**Subject:** Rezoning Petition Review

**Date of Review:** December 22, 2021

**Rezoning Petition #:** 21-195

**Location of Property:** Approximately 60.65 acres located on the north side of W Arrowood Rd, east of I-485 and south of Shopton Rd.

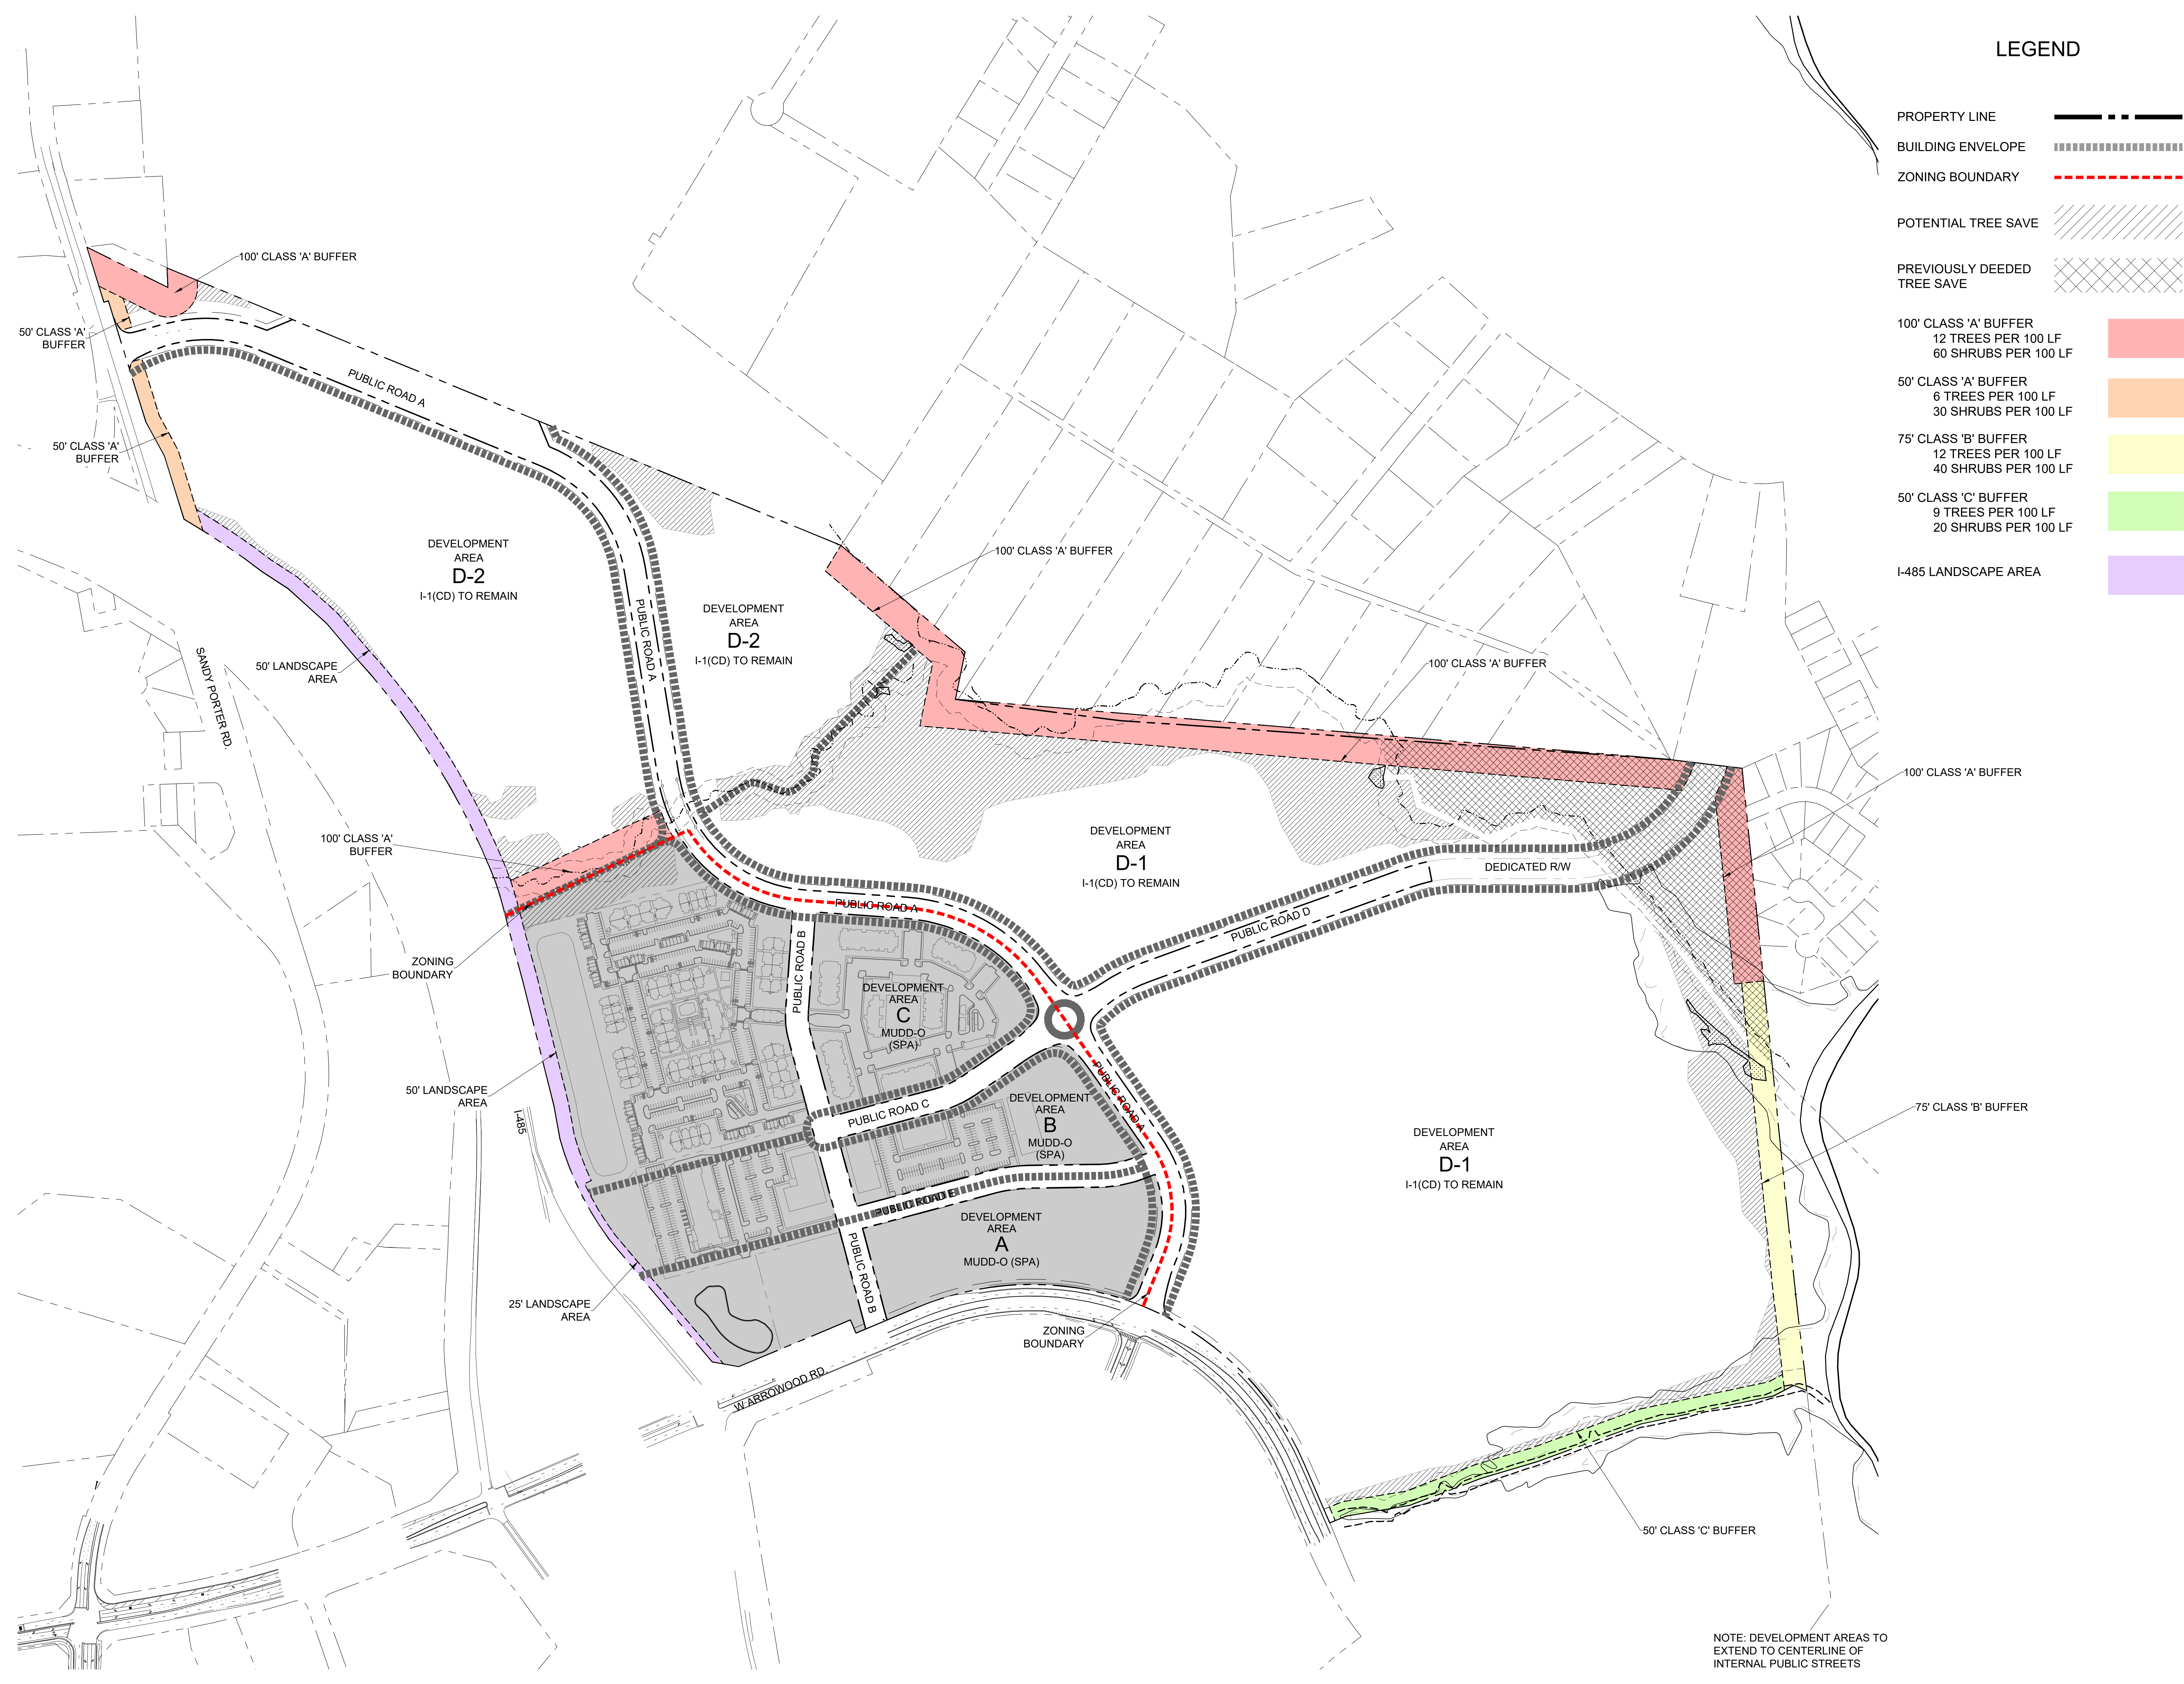
**Concerning Storm Water:** City of Charlotte GIS indicates a 30-ft PCSO Buffer on the site. Please show all buffers and include the following note under Environmental Features: *“Development within any SWIM/PCSO Buffer shall be coordinated with and subject to approval by Charlotte-Mecklenburg Storm Water Services and mitigated if required by City ordinance. Petitioner acknowledges intermittent/perennial stream delineation reports are subject to review and approval upon submission of development plans for permitting and are not approved with rezoning decisions.”*
